## PLANNING CONSULTATION RESPONSE

<b>Application No</b>	2025/0961
<b>Proposal</b>	2025 0961 C of U Vacant Chapel (Class F1) to Self-Storage (Class B8) Old Wesleyan Chapel Hoyland Road Hoyland Common
<b>Address</b>	Old Wesleyan Chapel Hoyland Road Hoyland Common
<b>Date of Consultation Reply</b>	181225 and 100226
<b>Consultee</b>	Tony Wiles Senior Conservation Officer

Proposed First Floor Plan
Scale 1:50

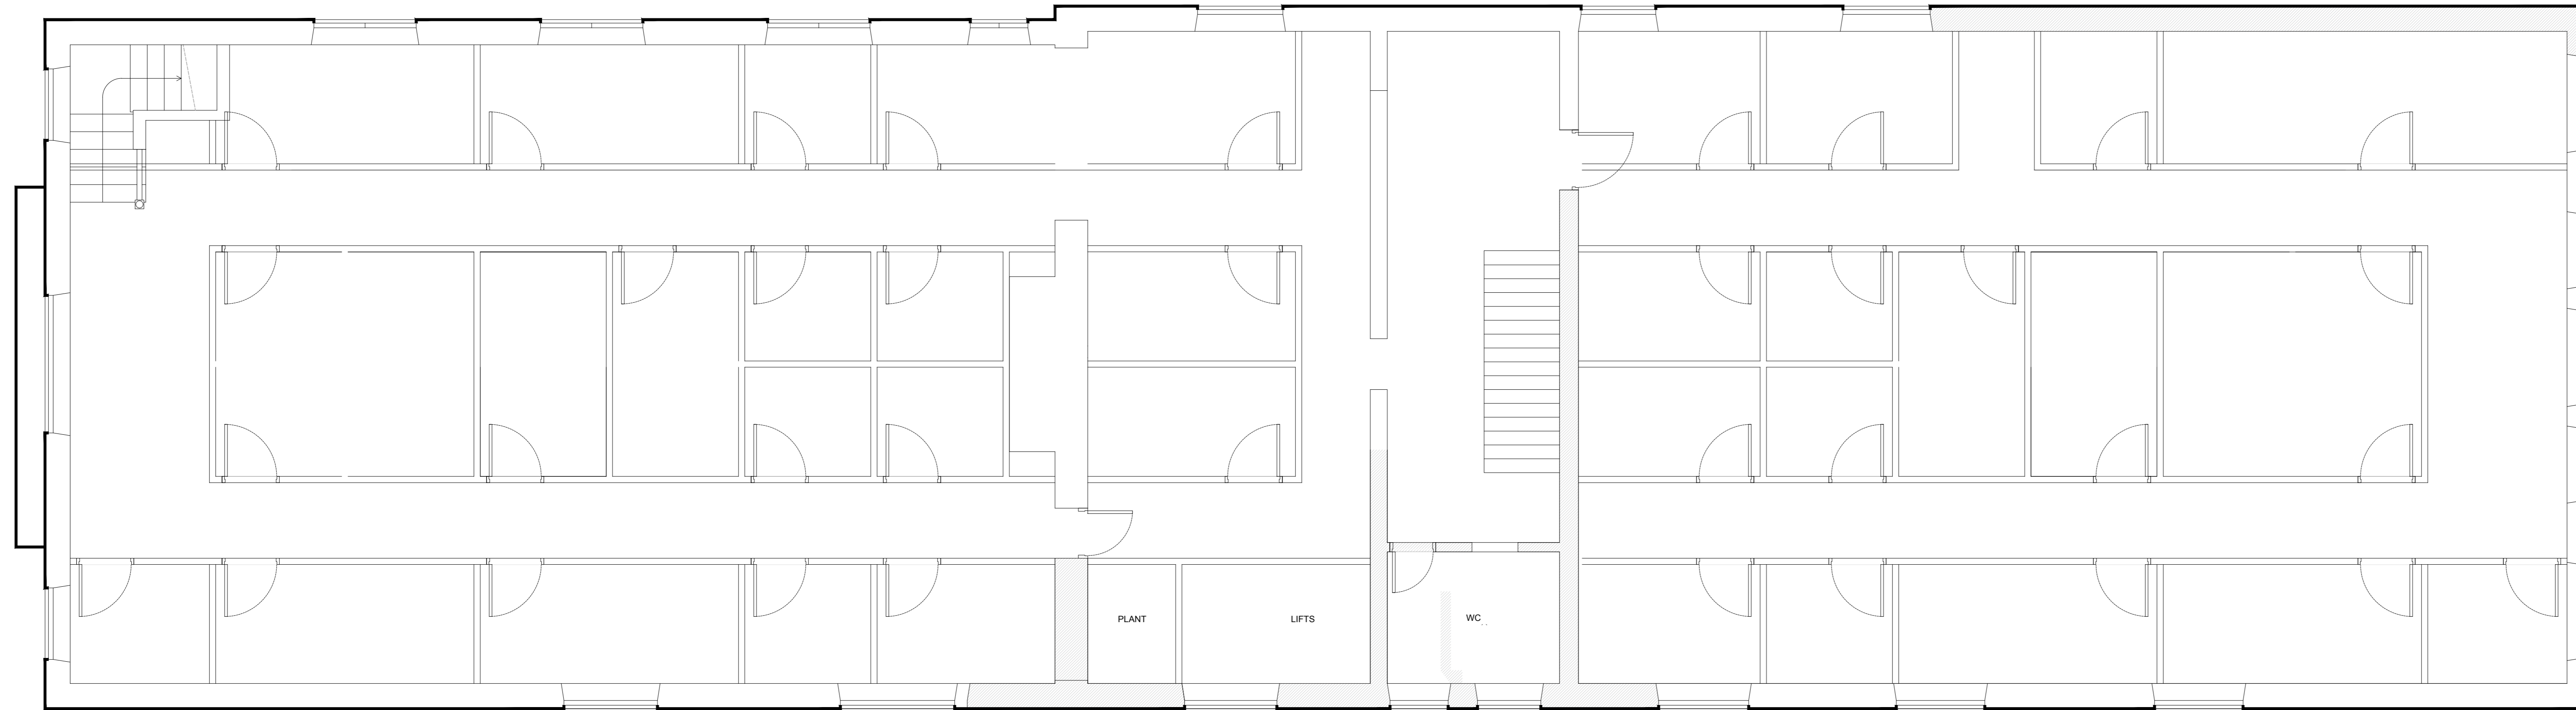
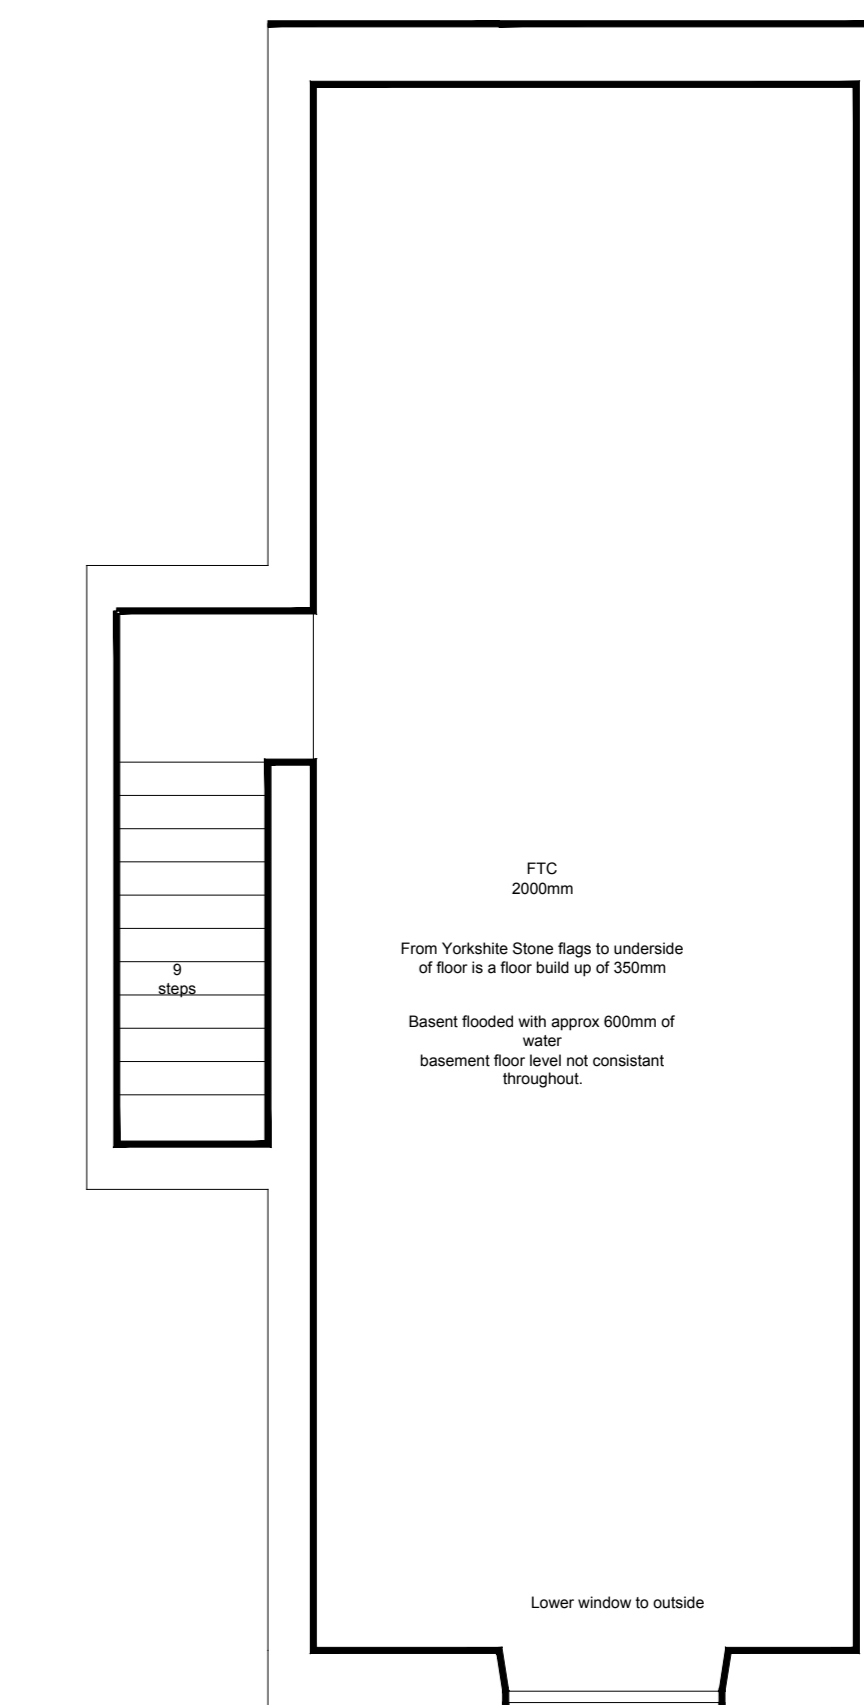
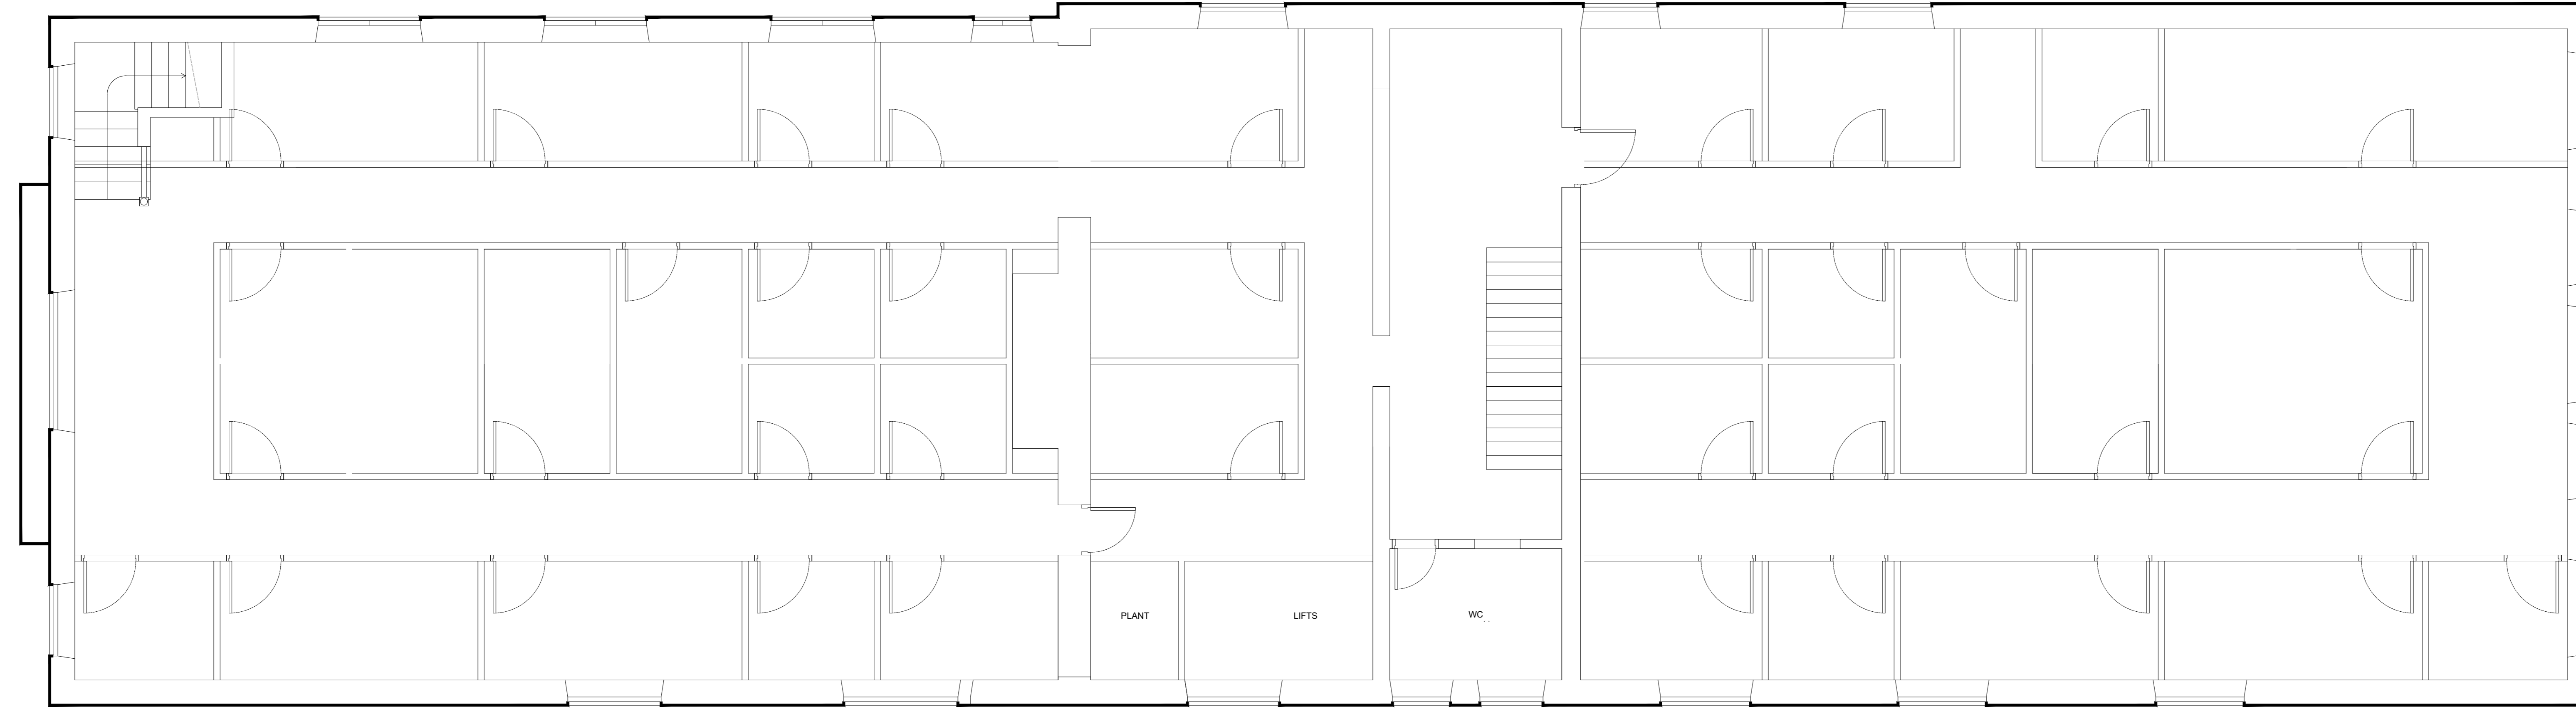
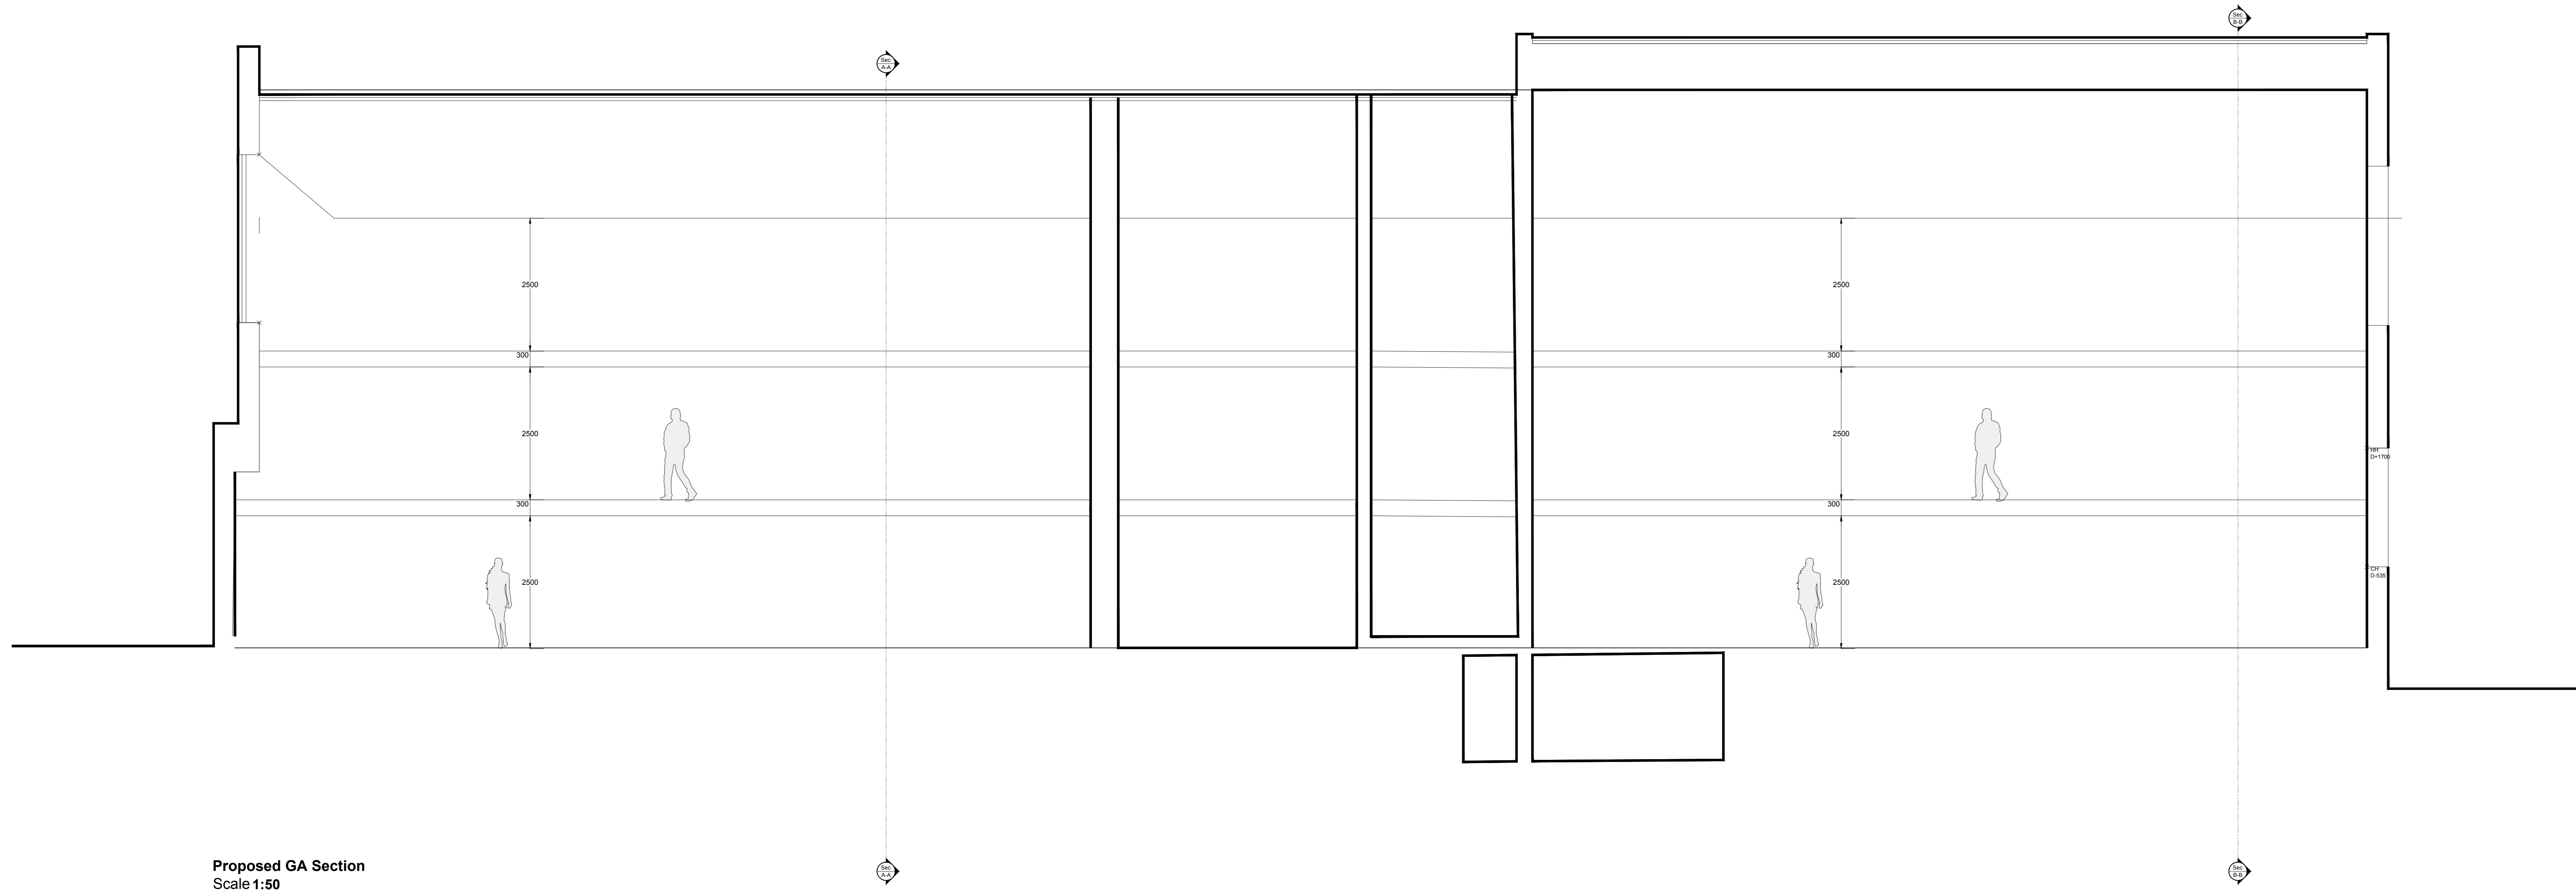
This application requests permission to change the use of the former Wesleyan Chapel on Hoyland Road, Hoyland Common from a place of worship to B8 – self storage. The proposal proposes no external alterations, but internally the auditorium and worship space will be demolished with a first and second floor inserted to provide storage space.

The lack of structures and features associated with the former place of worship and the obvious structural issues, subsidence and dilapidation including cracking, propping, internal decay (tongue and groove) are of note. Whilst the superstructure and general arrangement remain, I appreciate the internal alteration including the removal of the floors and internal structures could be carried out under permitted development. The existing internal arrangement and some surviving fabric remains, but I accept it has been altered and some has been removed eroding the significance of the NDHA. Ultimately, whilst I feel there is some harm in allowing the removal of floors etc. I am cognisant of the need for a new use for this building, without which it may be lost completely. As such, I feel on balance the internal alterations are justified in order to retain the envelope and in particular the façade of this former chapel.

Consequently, I accept the justification for the development and raise no further comments or objections.
